**Planning Act 2008 (as amended) and The Infrastructure Planning (Environmental Impact Assessment) Regulations 2017 (the EIA Regulations) – Regulations 10 and 11**

**Application by Teesside Flexible Regas Port Limited (the Applicant) for an Order granting Development Consent for the Teesside Flexible Regas Port Project (the Proposed Development)**

**Scoping consultation and notification of the Applicant's contact details and duty to make available information to the Applicant if requested**

Figure 7.2b
Statutory designated sites within 2km

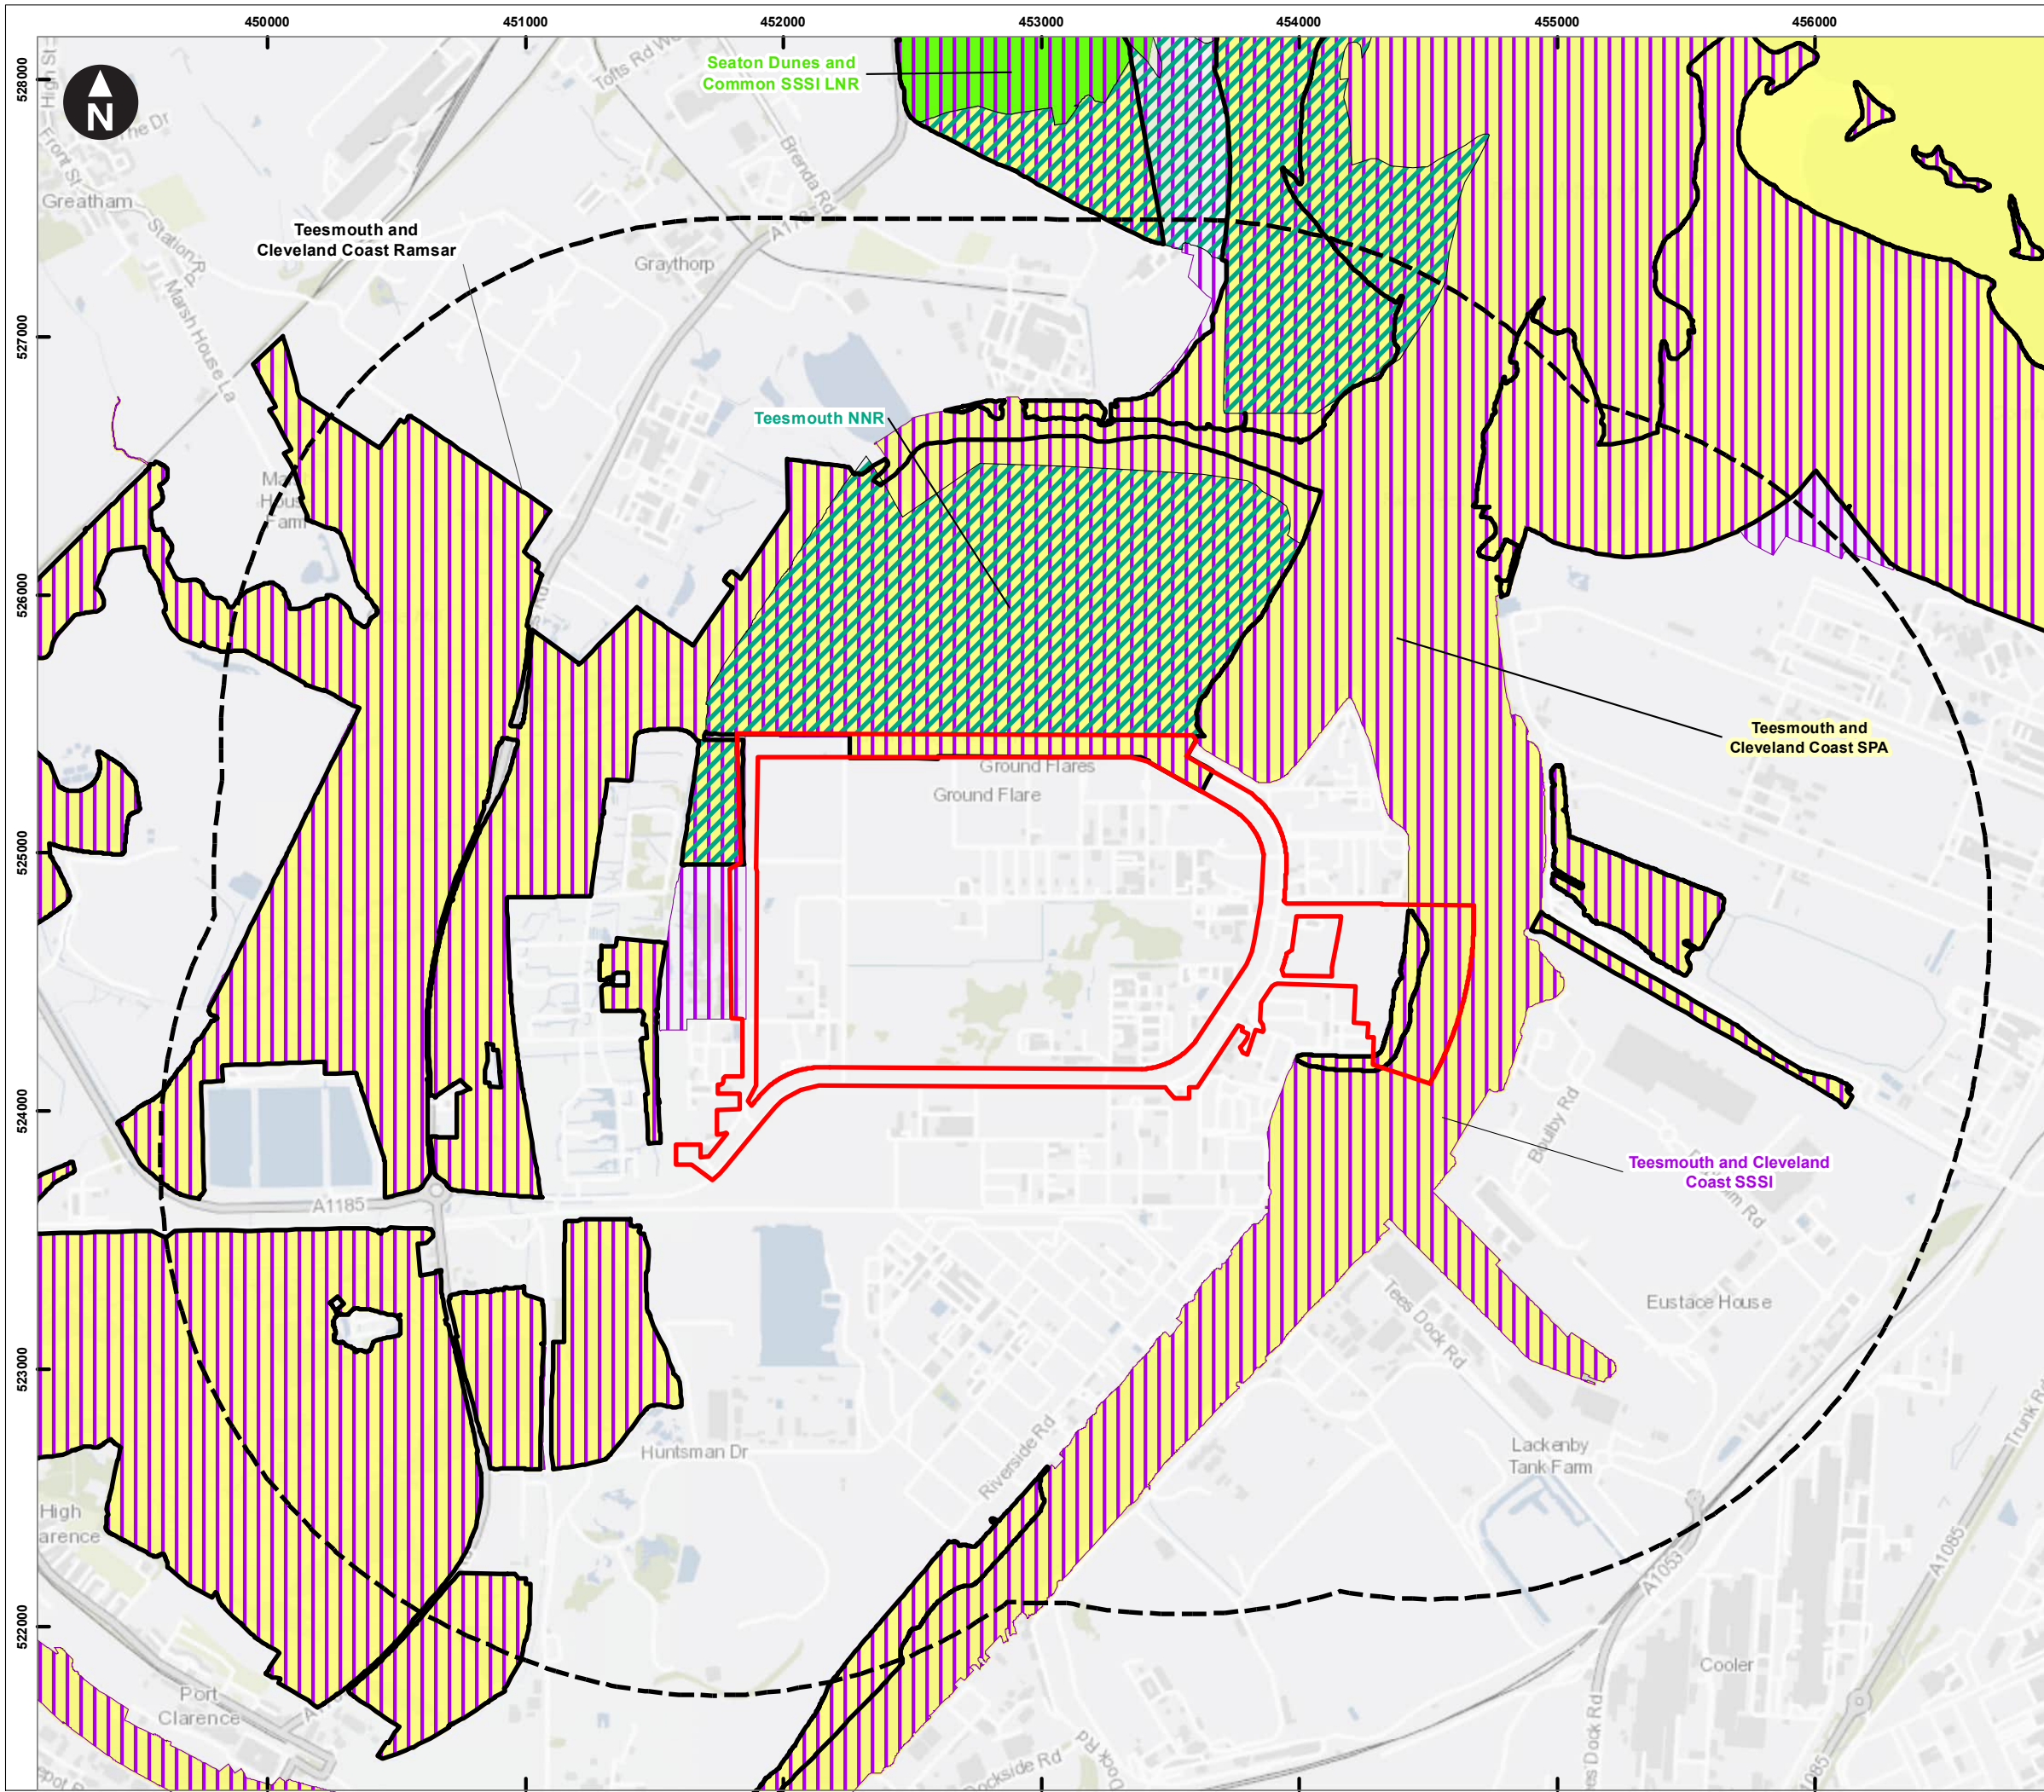
*Ecology* – The 2km study area is appropriate and has covered the Teesmouth and Cleveland Coast SPA part of which falls in County Durham.

**Figure 10.1
Site constraints within 2km**

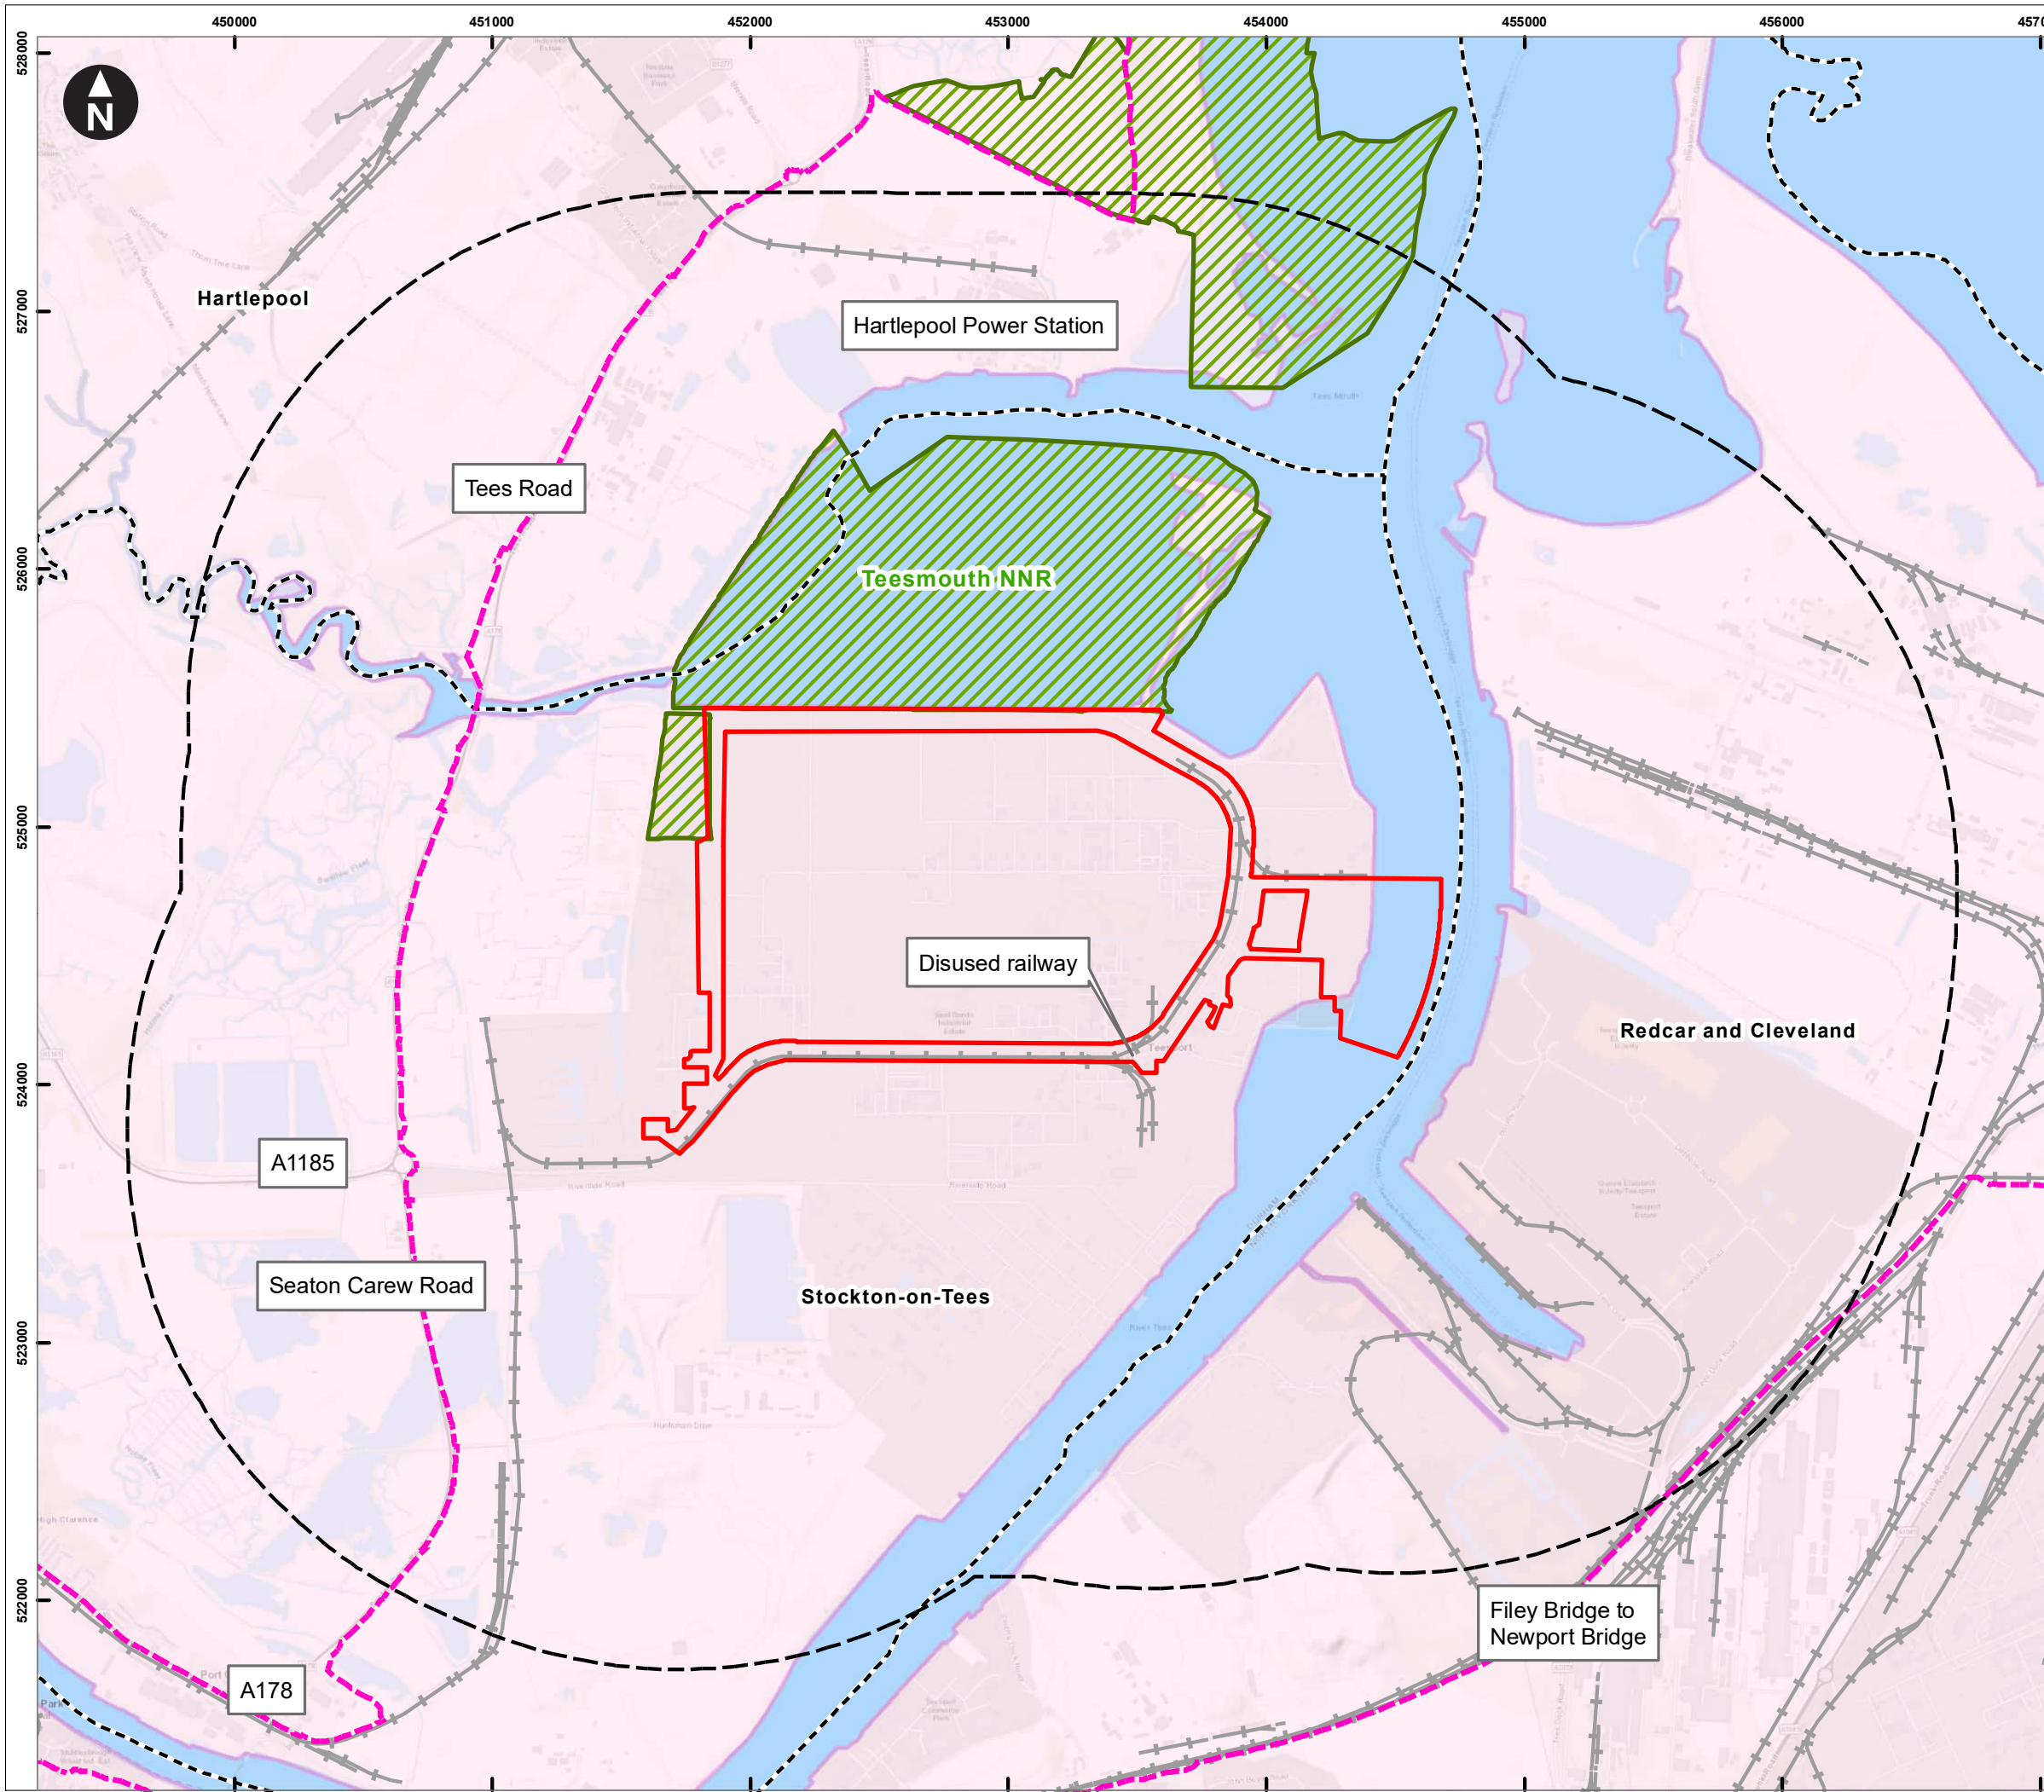
*Landscape* – The 2 km Landscape and Visual study area within the Scoping document is considered acceptable. Any impacts on County Durham would be negligible.
